Comments from Greenspace:

APPLICATION NO: A/23/15/OUT

Site Address: Land south of New Road (A259) and East of Brook Lane Angmering N/A

Description of Works: Hybrid application - Full Planning Permission for a retail unit (Class A1) comprising 1,487sqm (1022sqm ground floor and 465sqm mezzanine) with associated access, car parking, servicing, landscaping & associated works.
Outline Planning Permission for a public house (Class A4) comprising 581sqm at ground floor level - This is a Departure from the Development Plan

| Drawing Number<br>1117-P-11 | Revision<br>E    |

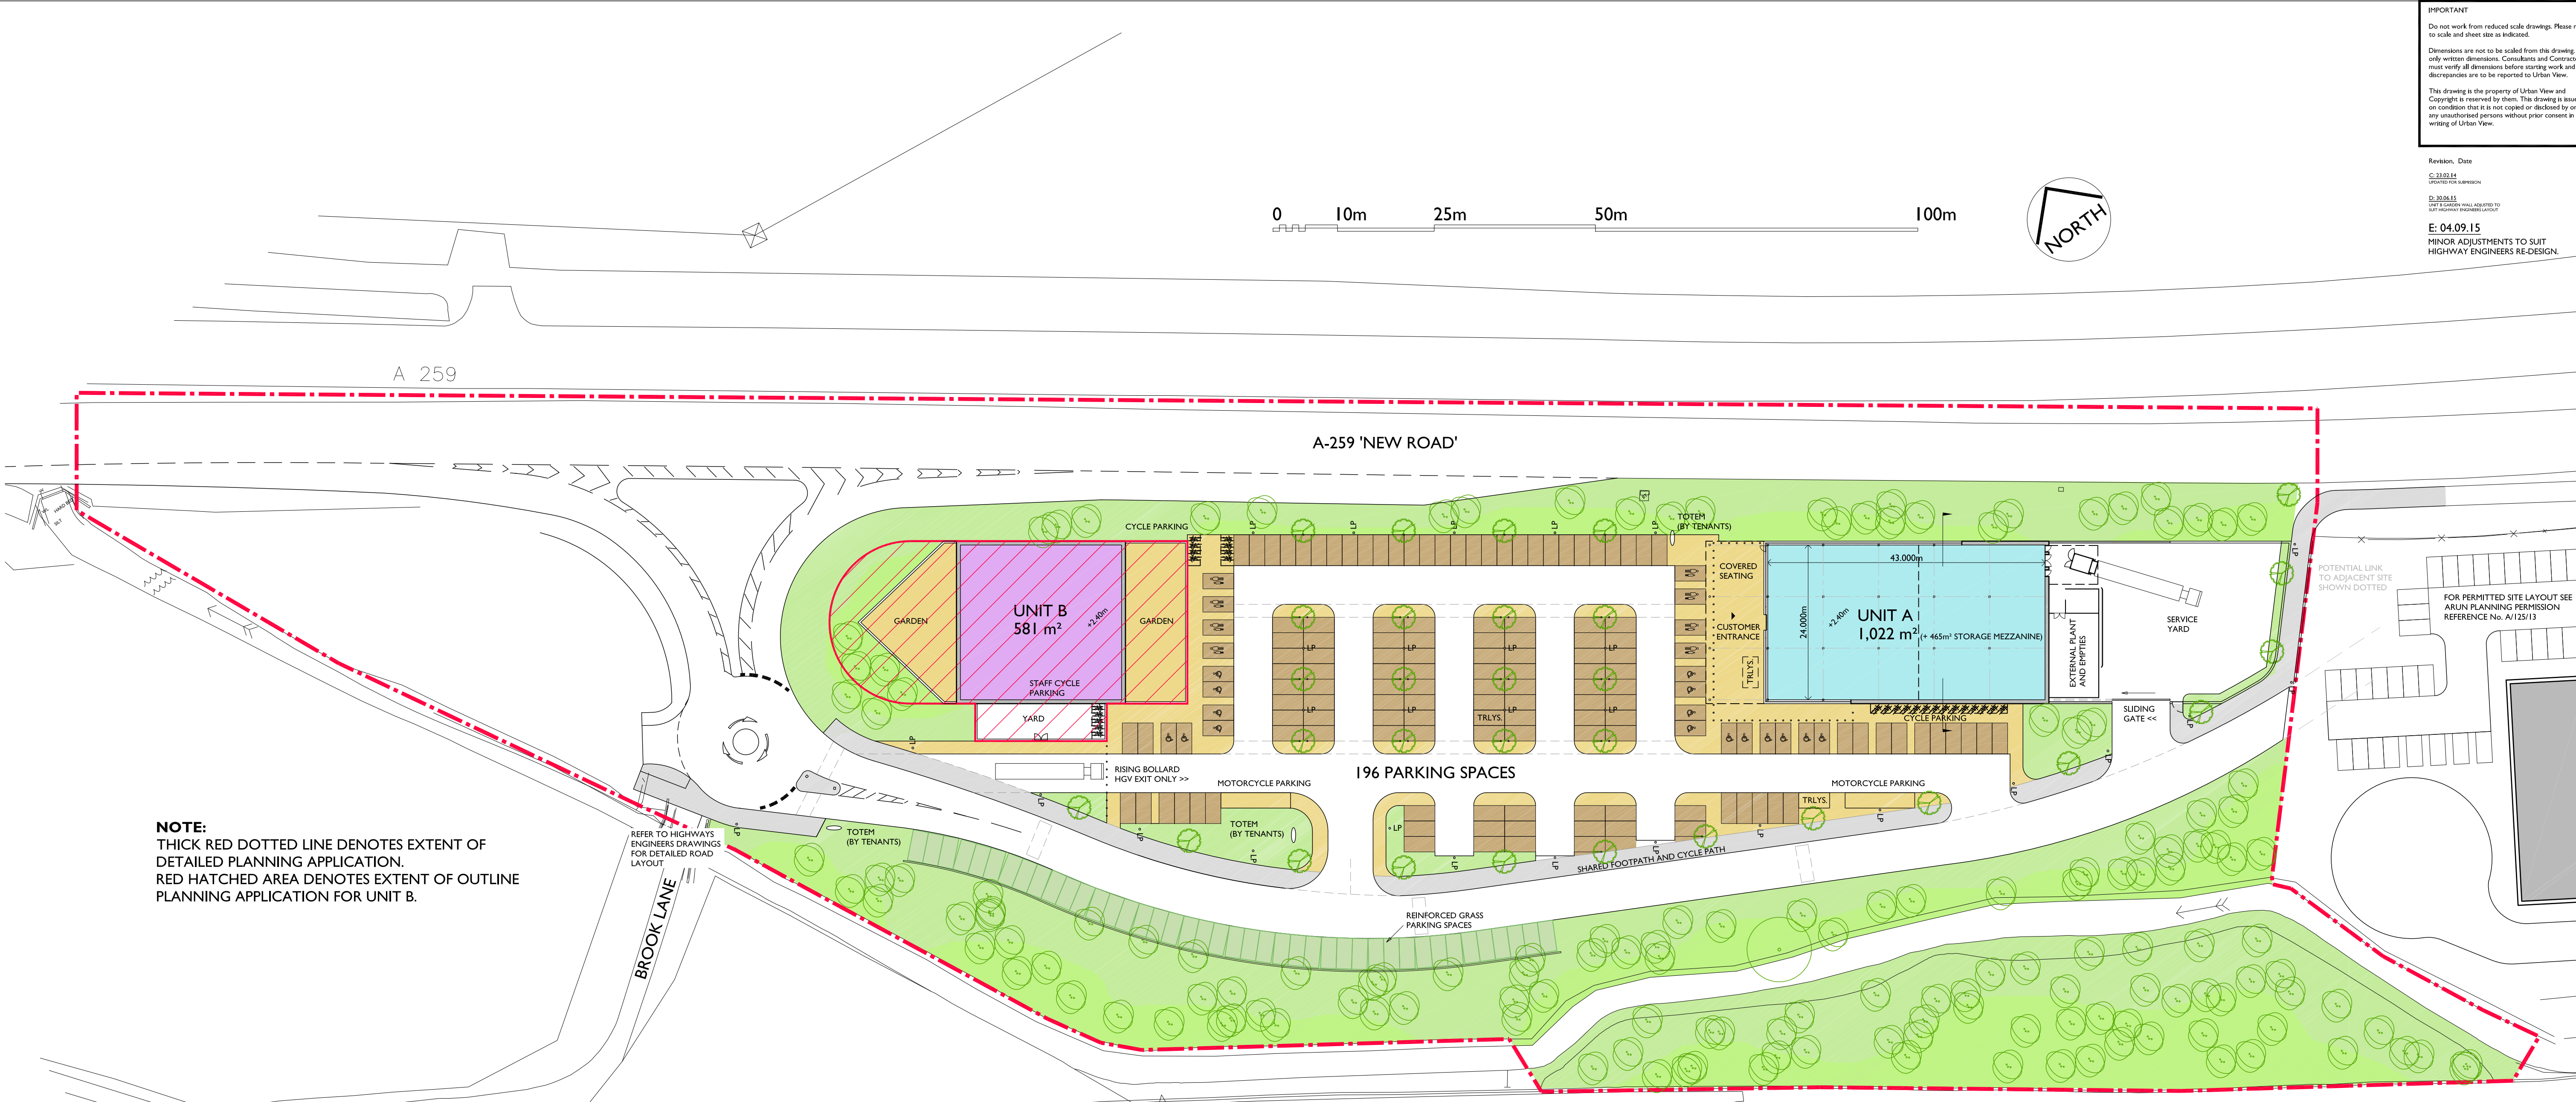
Our comments relating to the indicative nature of the scheme proposed does still not appear to have been addressed or a detailed landscaping scheme submitted for approval. Trees and shrubs to frontage to soften the scheme would be expected to be included in any proposals along with the detailing of that proposed.

Landscape drawings 1117-P-11 Rev C and KL.264.001 Rev C show indicative schemes, which whilst show a comprehensive mix are only an indicative layout. Plans would be required that detail a full landscape scheme submitted for approval. These would need to detail species choice, position, densities and size at time of planting. These should be plotted in plan and list form and in relation to the trees and vegetation to be retained so that a clear picture of the proposals can be seen. These details are required to ensure that appropriate screening is provided, maintaining and uncompromising the setting and ensuring that the proposals fit within the area of neighbouring development and properties and neighbouring South Downs National Park, whilst benefiting the potential of the proposed developments usage.

I would recommend that the above detail requires submission for approval.
